Robert Thompson <rmt@portlandmaine.gov>
To: Helen Donaldson <hcd@portlandmaine.gov>

Wed, Oct 31, 2018 at 8:30 AM

Here's the standard for Fire Department access.

Clearance Sign

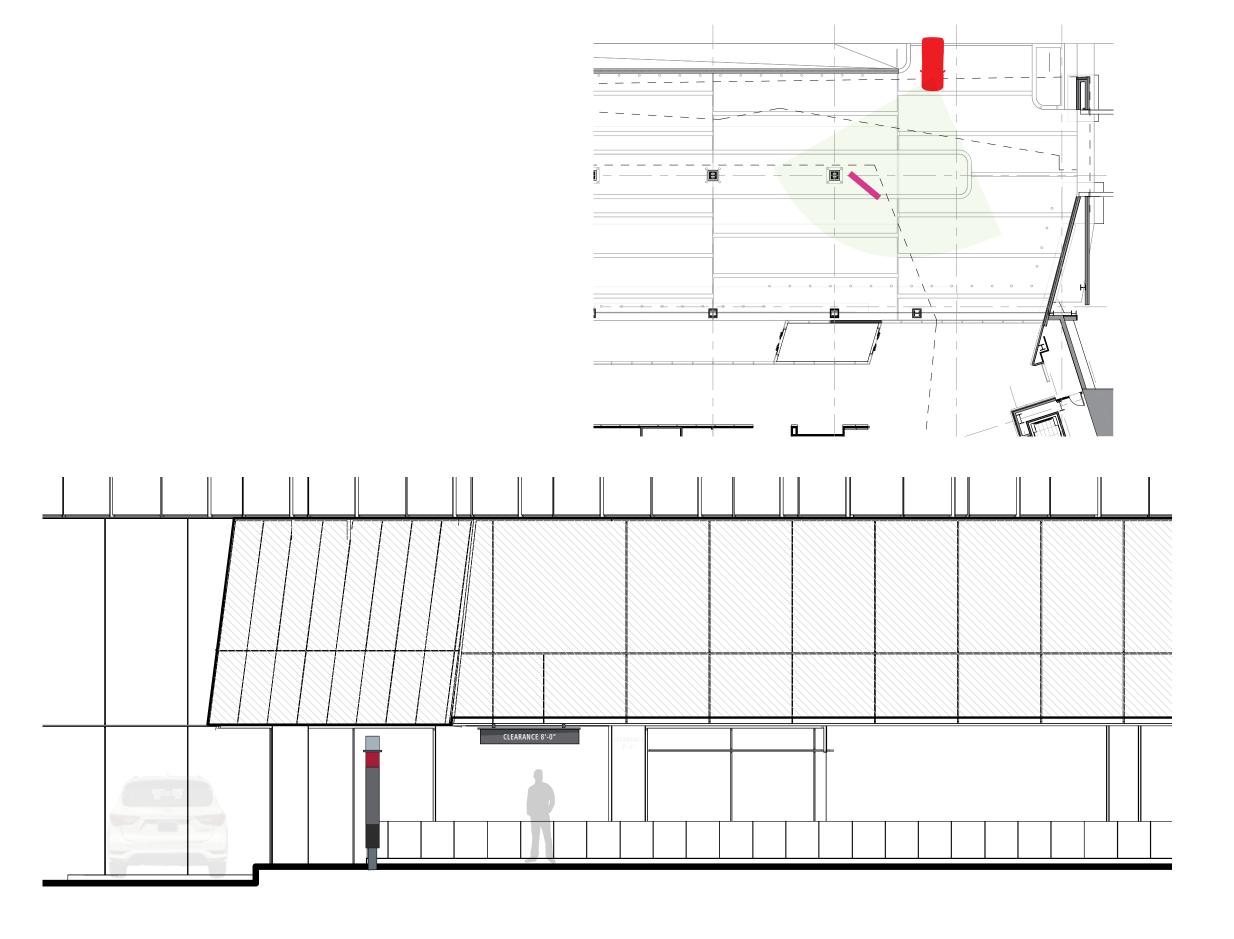
Because the drop off area is, for the most part, under the structure, I'd approve the 12 ft. clearance if signage indicating the clearance at the entrance of the drop off area is provided with a sign indicating passenger vehicles only.
